Our Case Number: ABP-316272-23

Re: Bus Connects Templeogue/Rathfarnham to City Centre Core Bus Corridor Scheme
Templeogue/Rathfarnham to City Centre

Ref: Application 316272 Templeogue/ Rathfarnham to City Centre Bus Connects

Programme Title BUSCONNECTS DUBLIN CORE BUS CORRIDORS INFRASTRUCTURE WORKS				
Drawing Title TEMPLEOGUE / RATHFARNHAM TO CITY CENTRE CORE BUS CORRIDOR SCHEME TRAFFIC SIGNS AND ROAD MARKINGS				
Drawing File Name BCIDC-ARP-TSM_GA-1012_XX_00-DR-CR-0012	Sheet Number 12 of 42	Status A	Rev M01

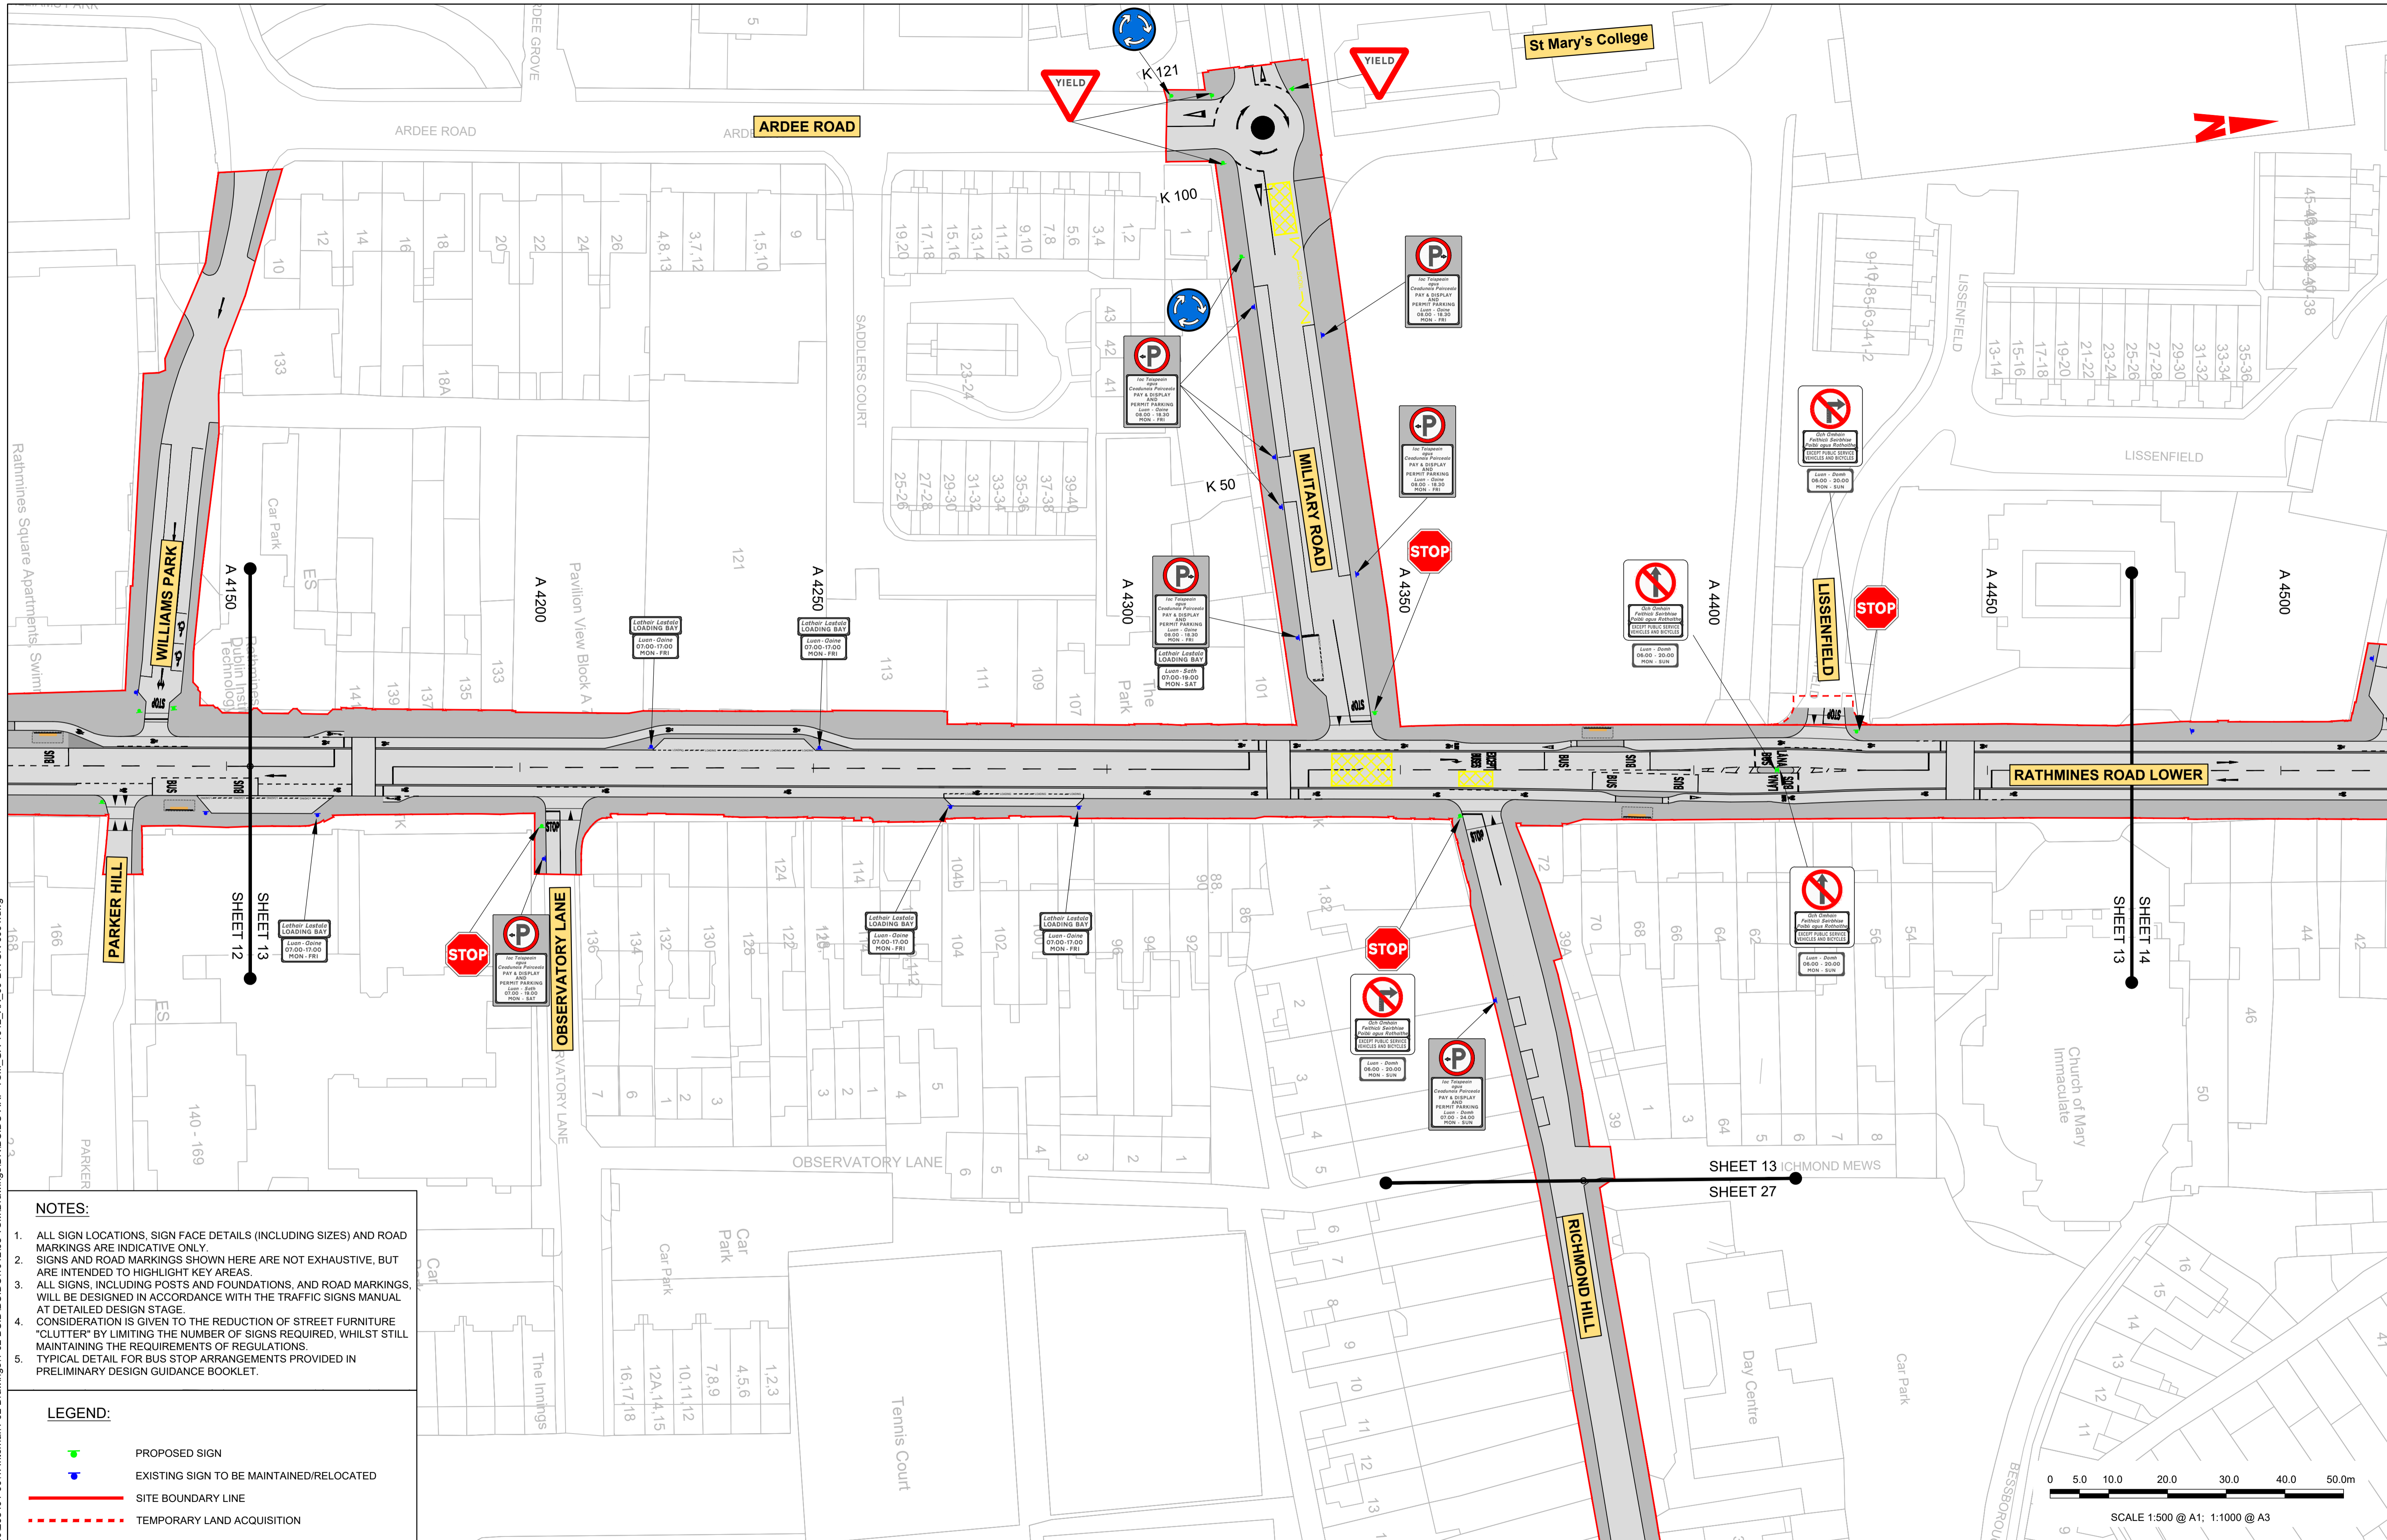
The removal of the Left Turn filter (as shown on 08.-Traffic-Signs-Road-Marking.pdf – Page 9) will cause a major issue for large vehicles including Vans and trucks turning into Terenure Place from Rathfarhamn Road. This turn is already an issue as traffic regularly has wait for Terenure Place to partially clear to swing over the line to get the turn, up to Templeogue Road / Terenure Road West junction .

Programme Title BUSCONNECTS DUBLIN CORE BUS CORRIDORS INFRASTRUCTURE WORKS			
Drawing Title TEMPLEOGUE / RATHFARNHAM TO CITY CENTRE CORE BUS CORRIDOR SCHEME TRAFFIC SIGNS AND ROAD MARKINGS			
Drawing File Name	Sheet Number	Status	Rev
BCIDC-ARP-TSM_GA-1012_XX_00-DR-CR-0036	36 of 42	A	M01

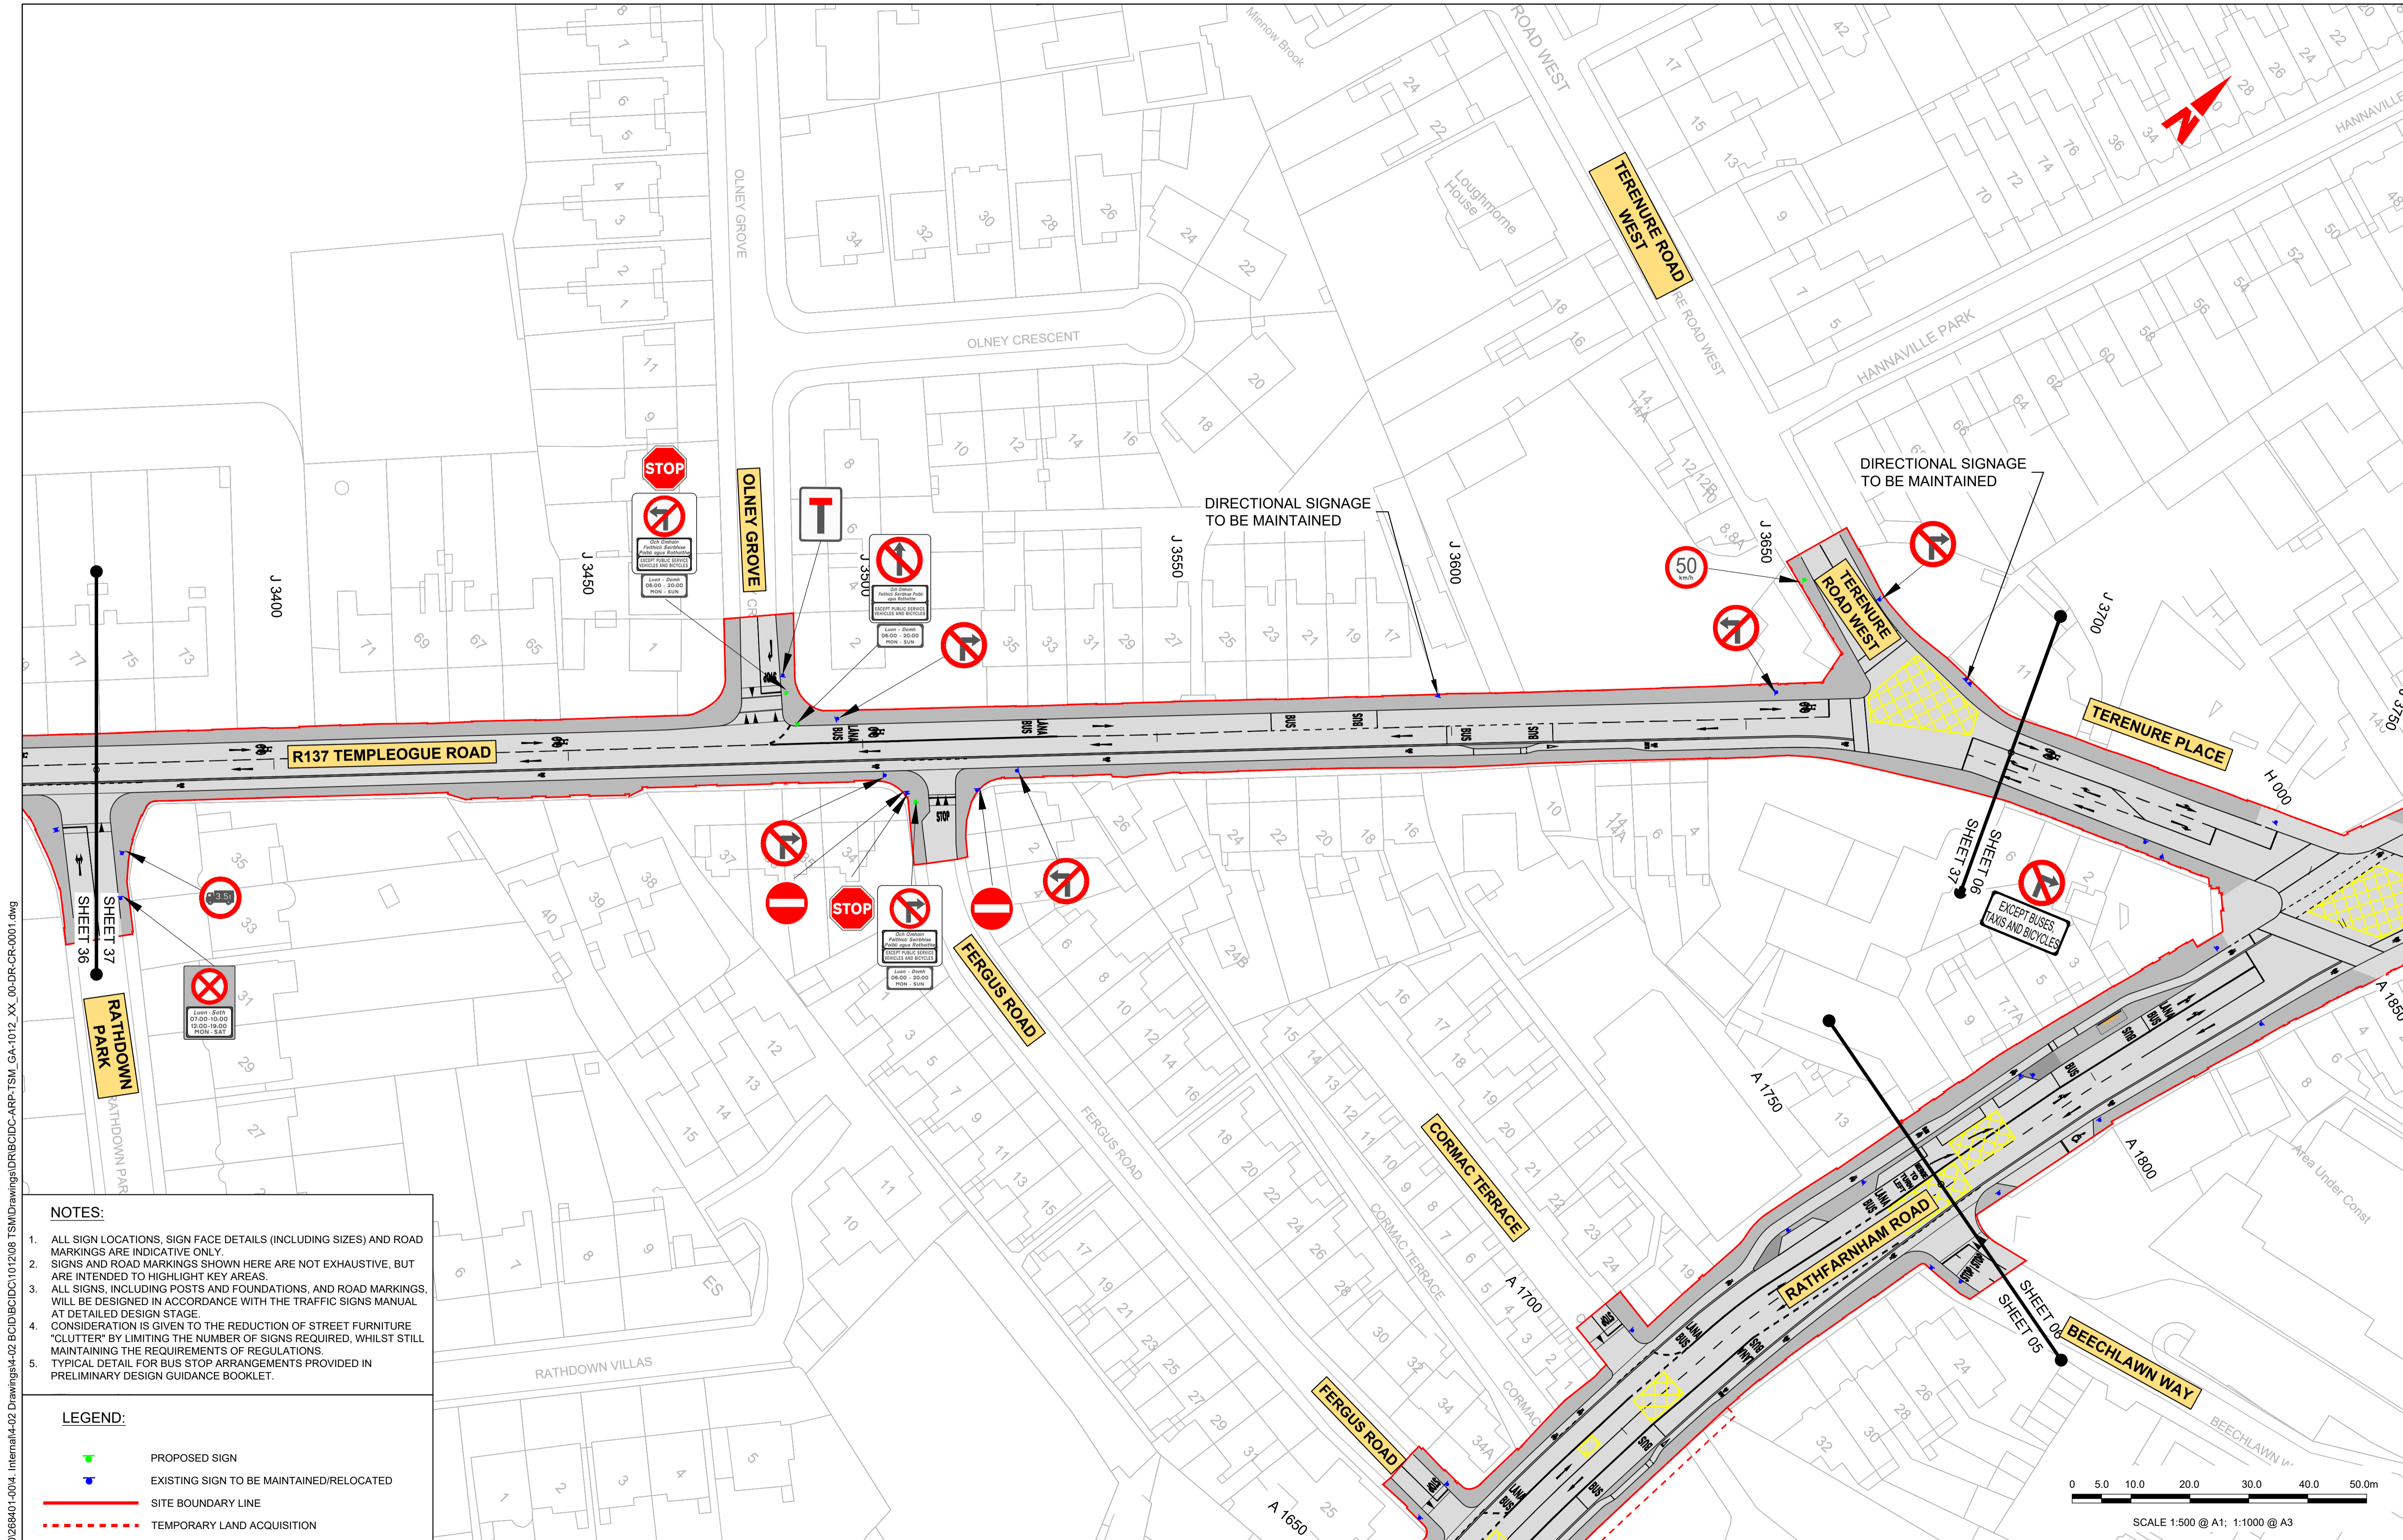
An example of how more revision and planning needs to be put in to the Bus Connects project is at the Junction of Templeogue Road, Templeville Road and Springfield Avenue, from map **08.-Traffic-Signs-Road-Marking.pdf (page 36 of 45)** there is no separate Right hand lane or Turn light for Traffic turning onto Springfield Road from Templeogue Road. This will cause large delays and back traffic into Templeogue Village especially when commercial vehicles like trucks and articulated lorries are planning to turn right onto Springfield Road. The consequences of this will be to backup the traffic into Templeogue Village which will also block the Bus getting through the village and delay it on its route. The same can be seen in several junction designs across the documentation like KCR which is only a short distance away.
